Amended Plans Form

Application Number: 11/00282/DISC

Address (including postcode): Portway
Heyford Park

Summary of amendments/additions (Note: this is the extract text that will go out on the consult letters): Please find attached an updated drawing (drawing ref: D.0342_51-1F) as requested with the edging material removed entirely and excavating a further 150mm and adding another 150mm of Coxwell Gravel.

Heyford Park - Proposed Bridleways Routes

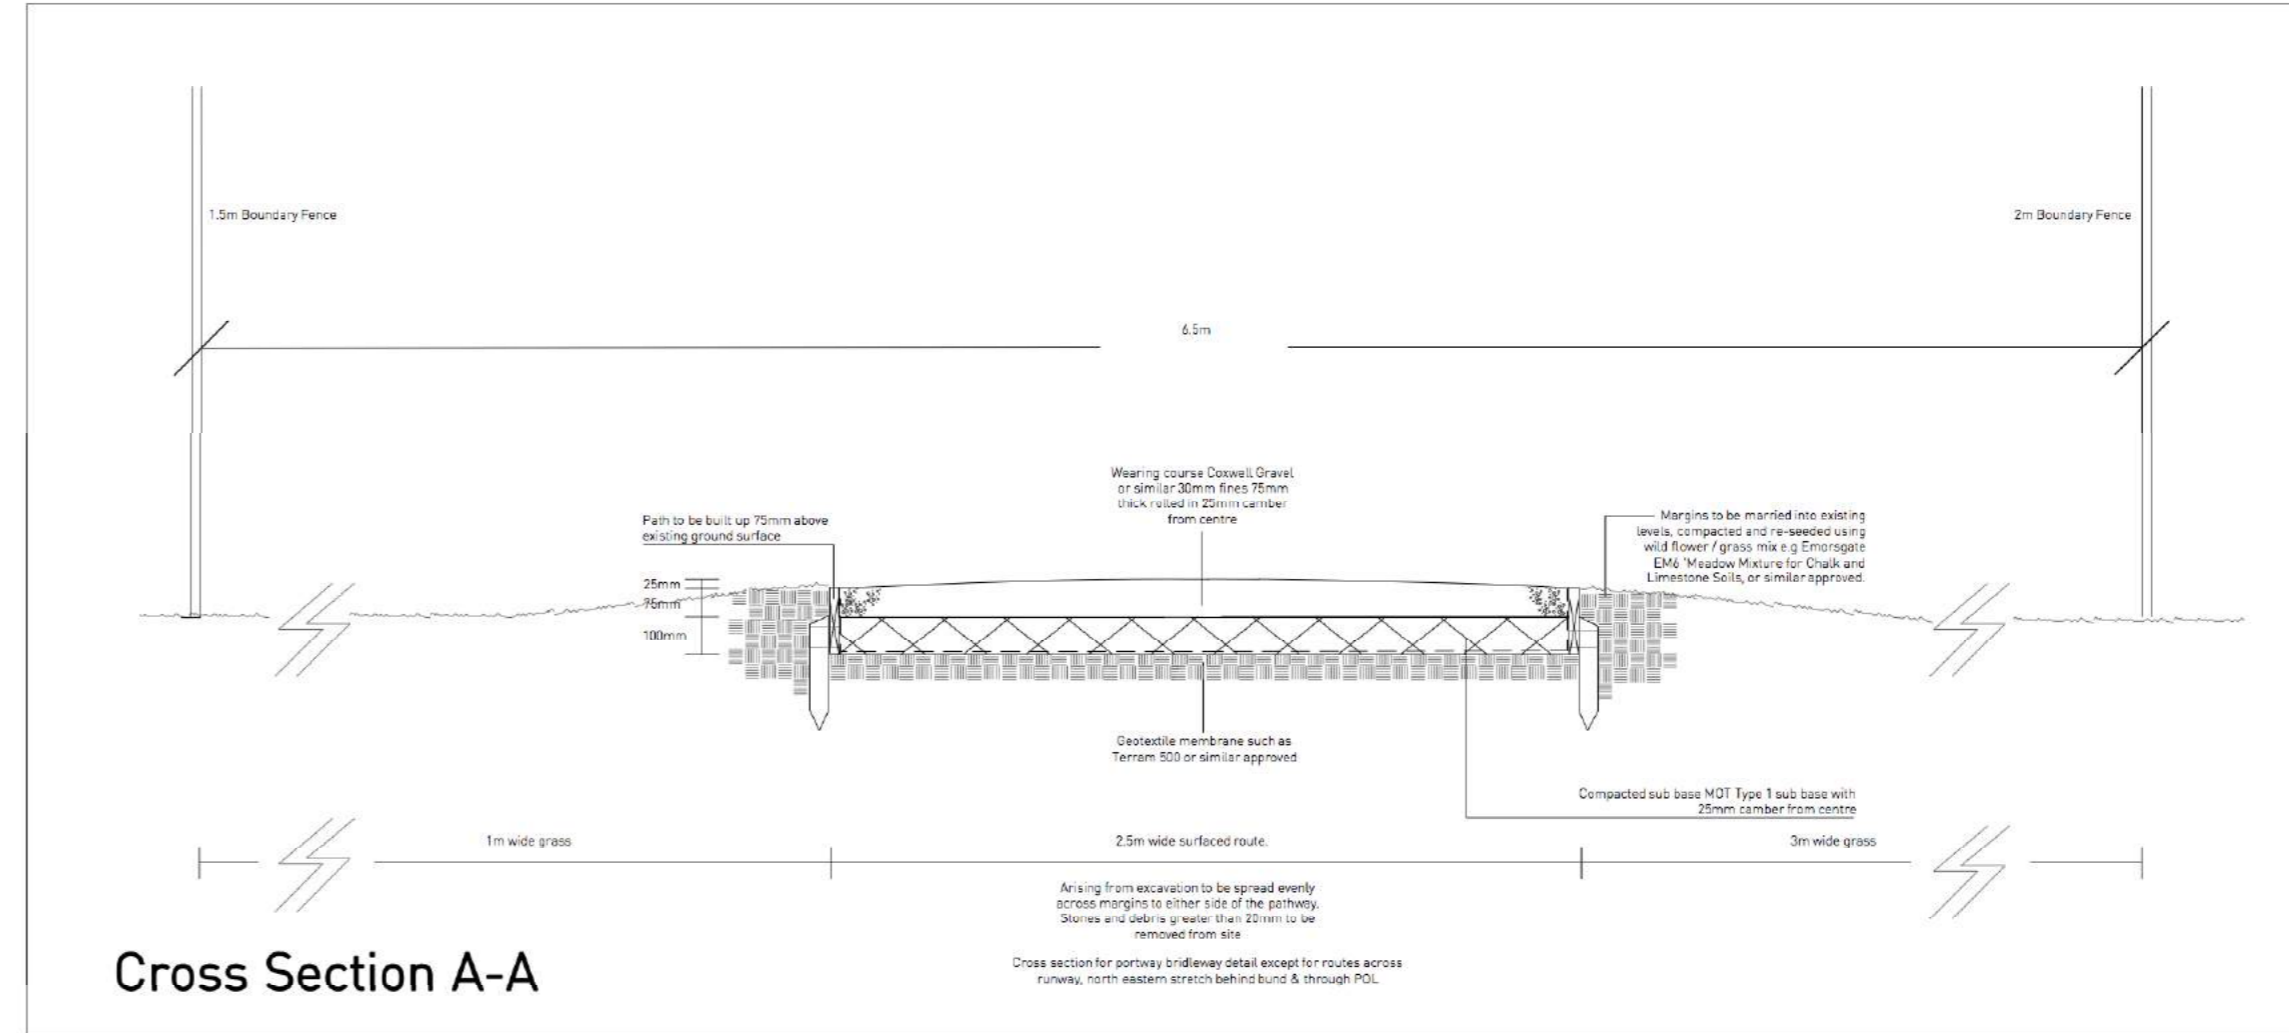
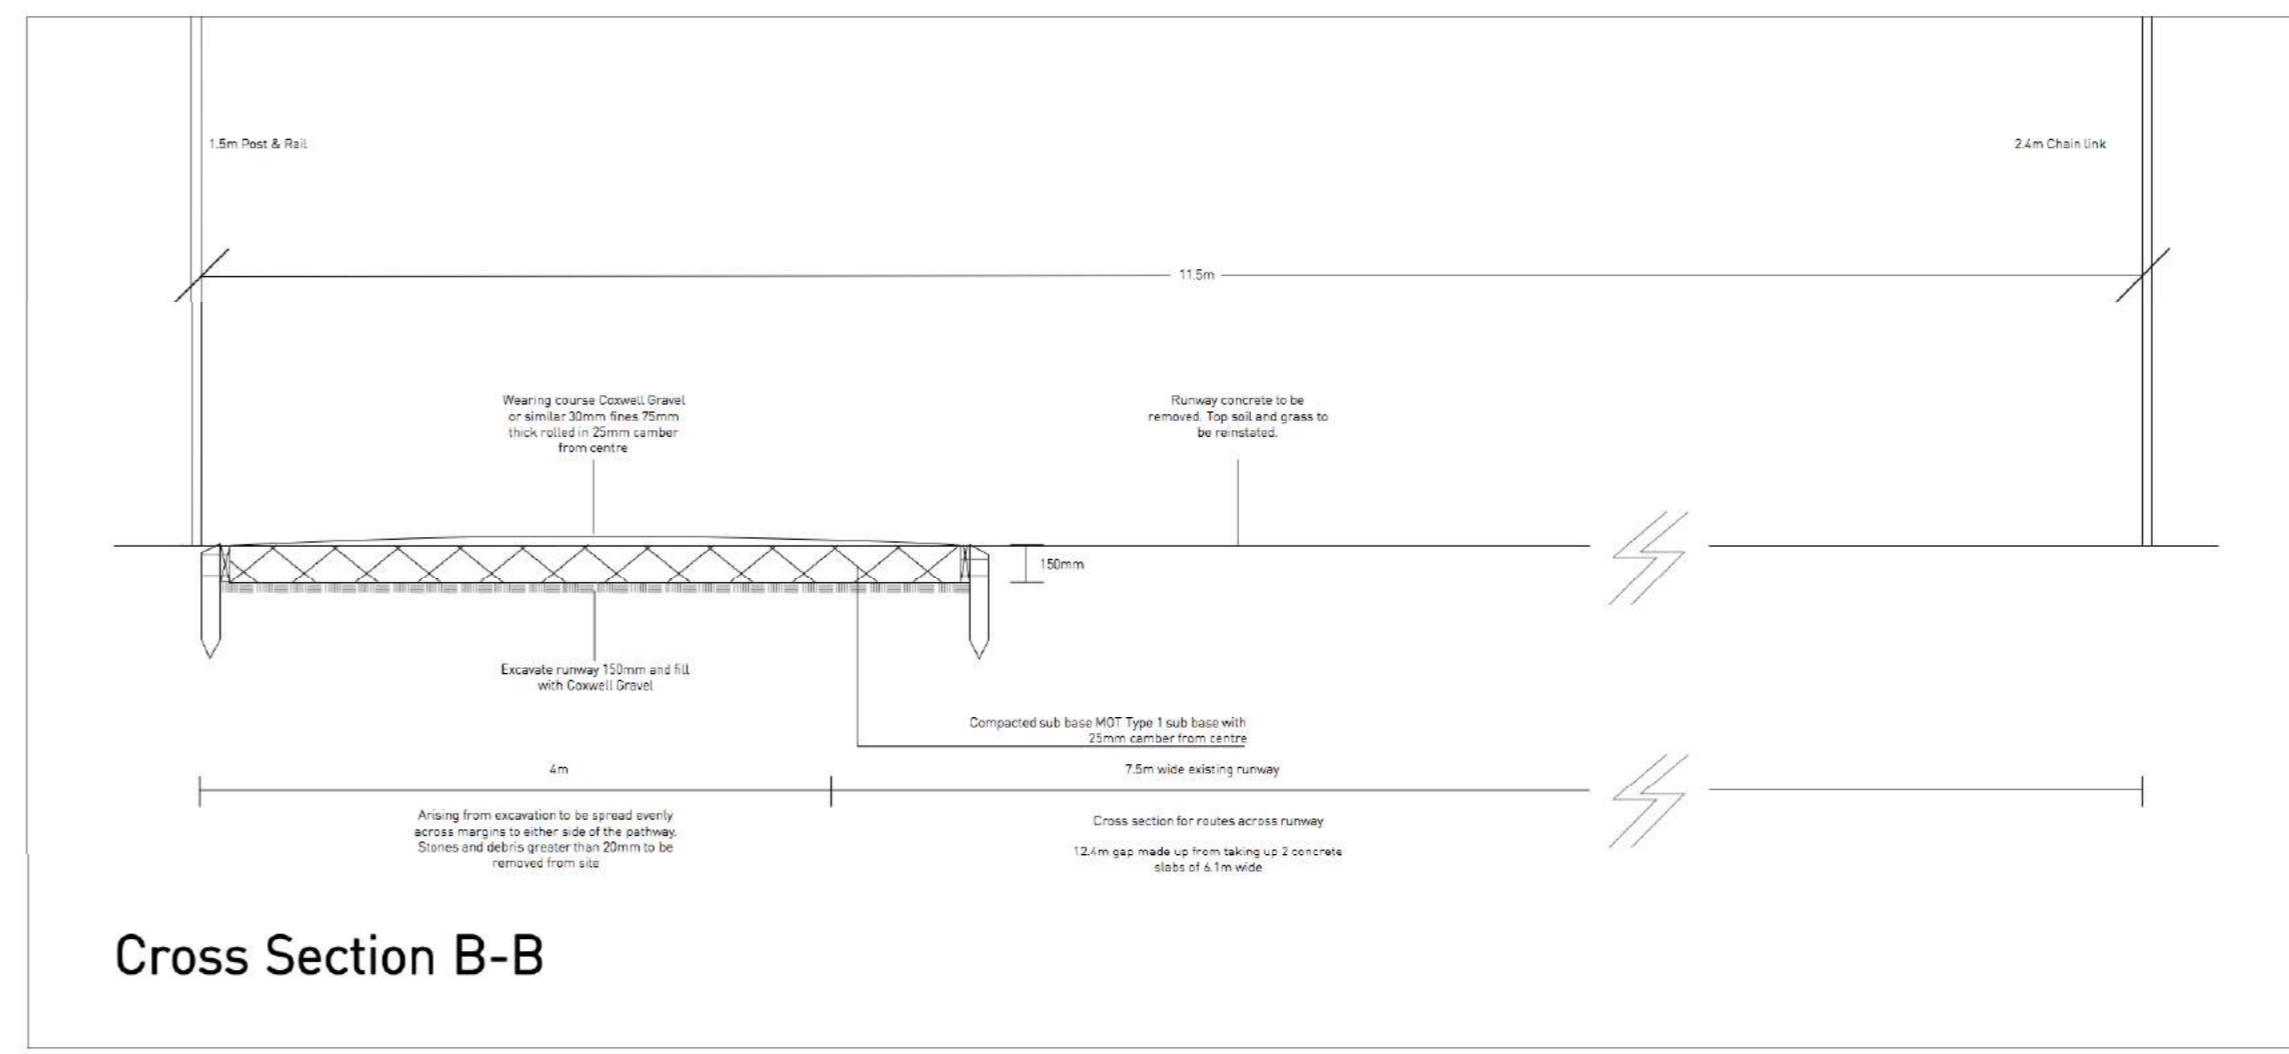
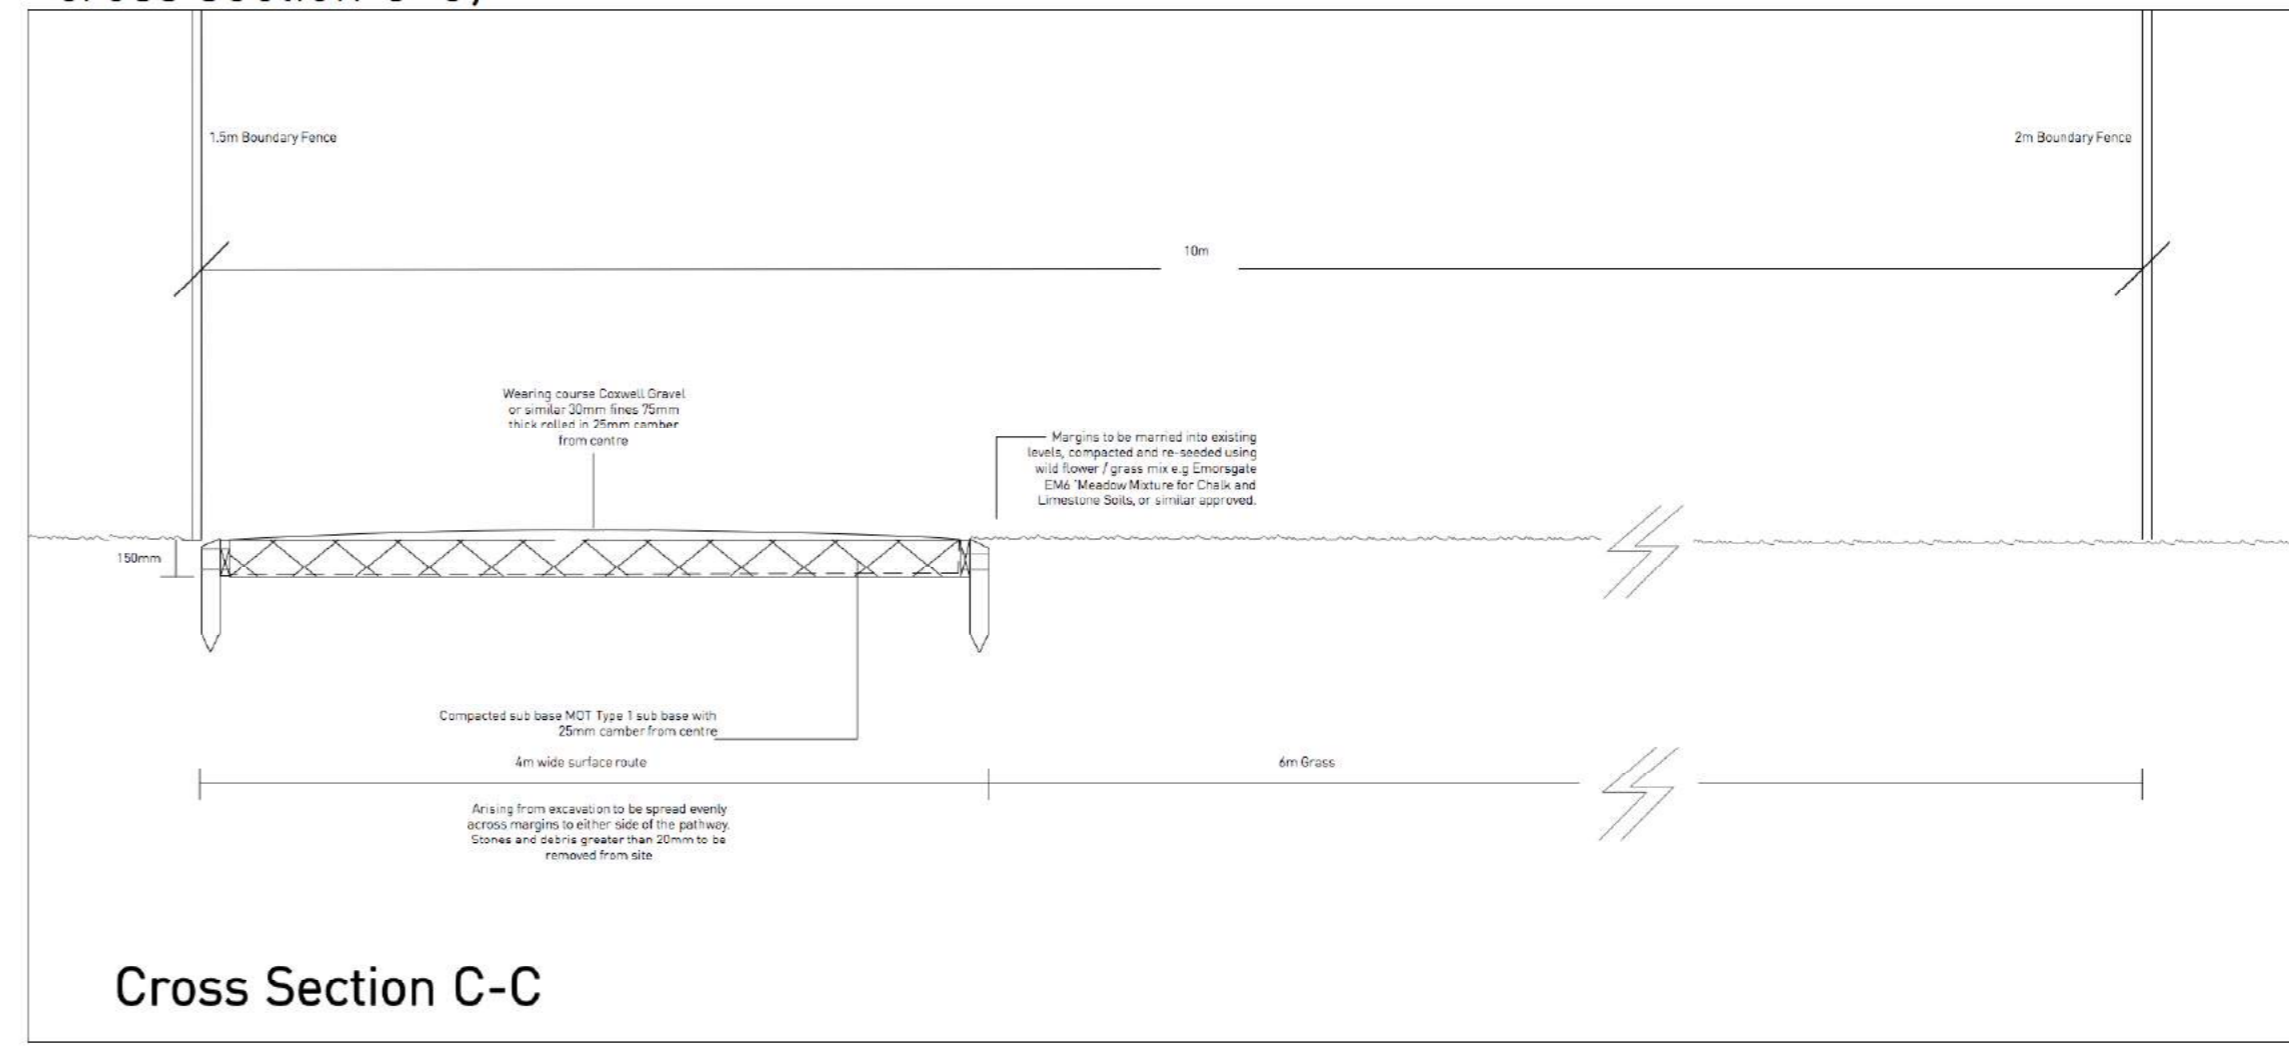
The submitted drawing supersedes drawing ref: D.0342_51-1C previously submitted.
